Office of
Environment
& Heritage

Your reference: SSD 4966
Our reference: DOC15/81519-01
Contact: Steve Lewer, 4908 6814

**RE: COMMENTS ON REVISED CONDITIONS FOR STRATFORD EXTENSION PROJECT (SSD-4966) –
STRATFORD COAL PTY LTD**

ATTACHMENT A: COMMENTS AND SUGGESTED CHANGES TO REVISED CONDITIONS OF CONSENT – STRATFORD EXTENSION PROJECT (SSD-4996)

Figure 1: Location of Stratford Biodiversity Offset Areas

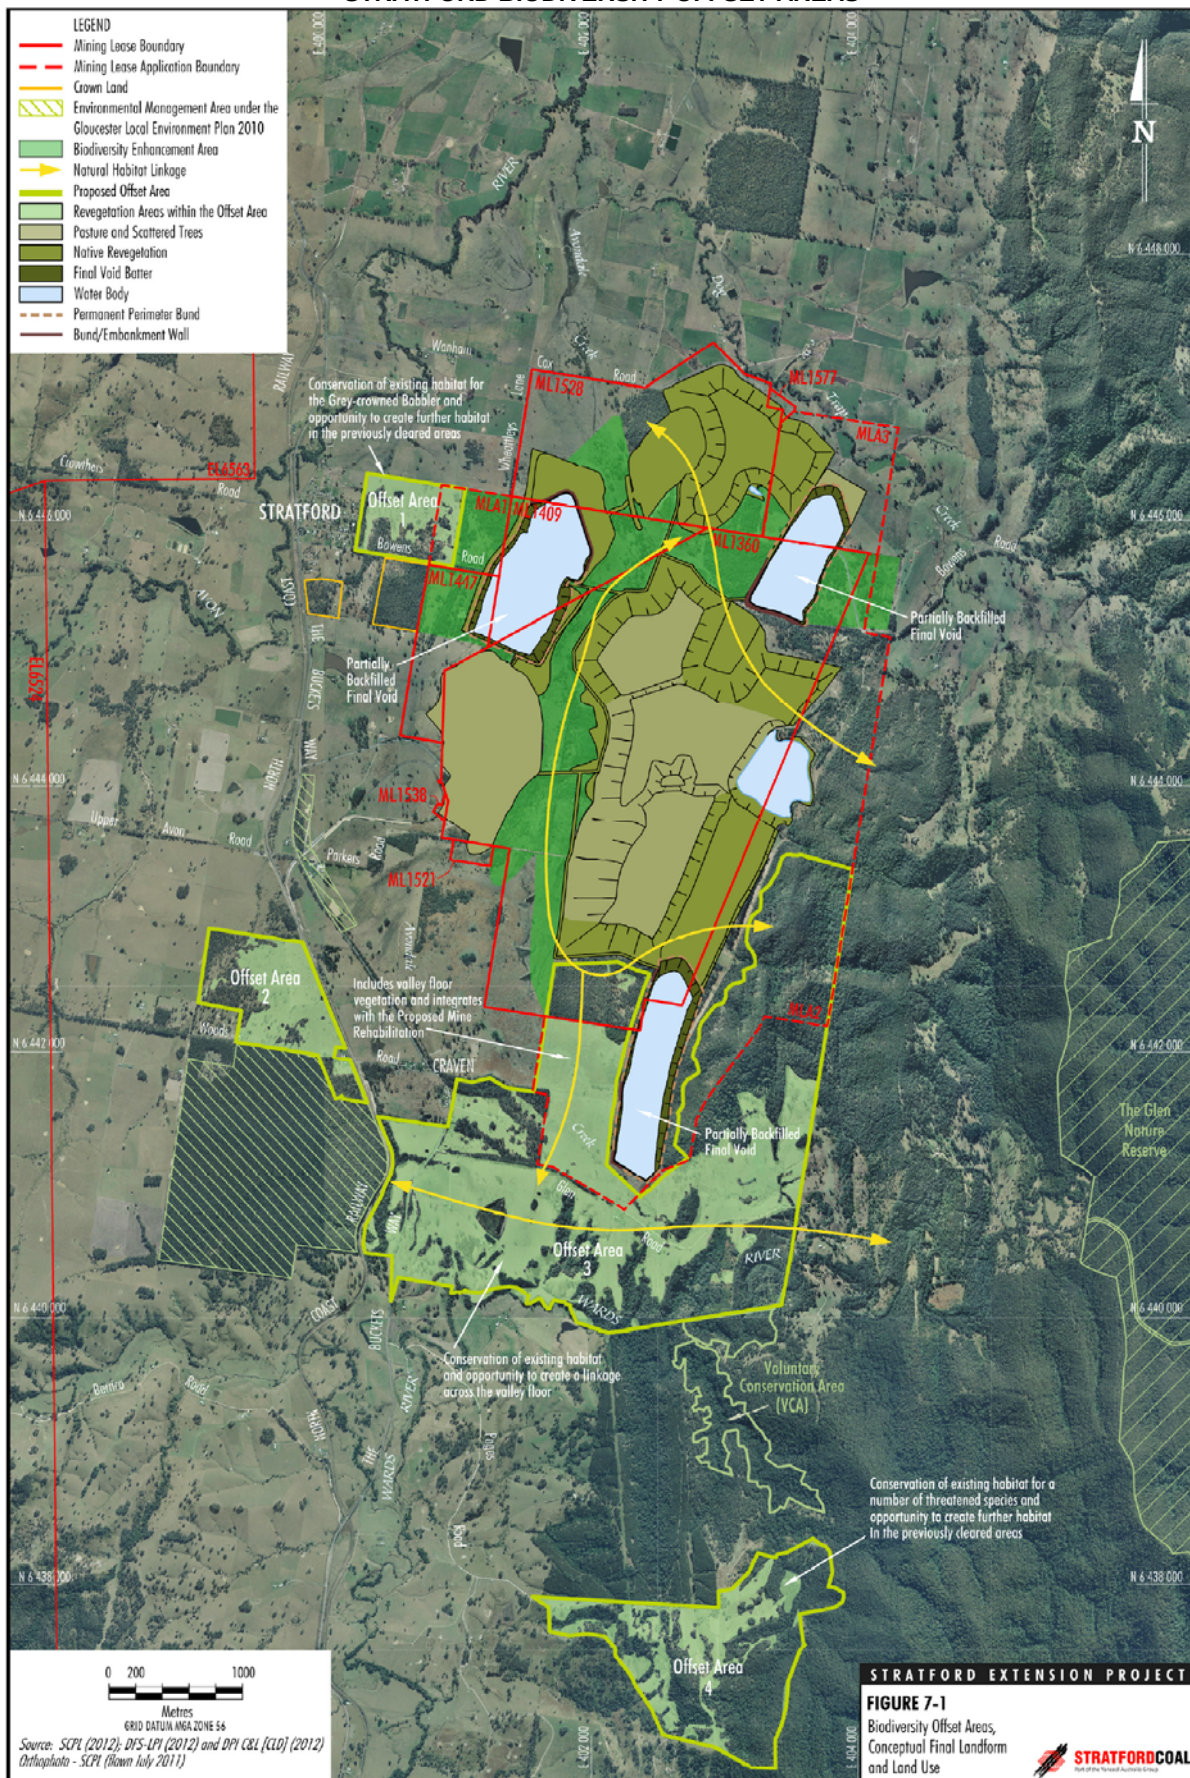
OEH supports the development of a management plan to help secure and manage the Squirrel Glider populations / family groups on the proposed Biodiversity Offset Area (including Property 44 if secured), Biodiversity Enhancement Area and within the project area in general.

OEH notes that the vegetation which is to be retained to the south east of the Bowen Road North Pit contains a record of a Squirrel Glider. This parcel of vegetation appears to be fragmented and isolated from other patches of suitable habitat where Squirrel Gliders have been recorded (i.e. to the west near Stratford). To facilitate movement between these patches and the previously mentioned parcel, OEH recommends that installation of glider crossings (such as 'gliding poles'). OEH notes that Condition 39 stipulates crossings for major movement impediments associated with The Bucketts Way and the Main Northern Railway, and as such recommends that such crossing be provided for the Bowen Road North patch of vegetation. Additionally plantings that contain suitable feed trees may also help to assist movement in these areas.
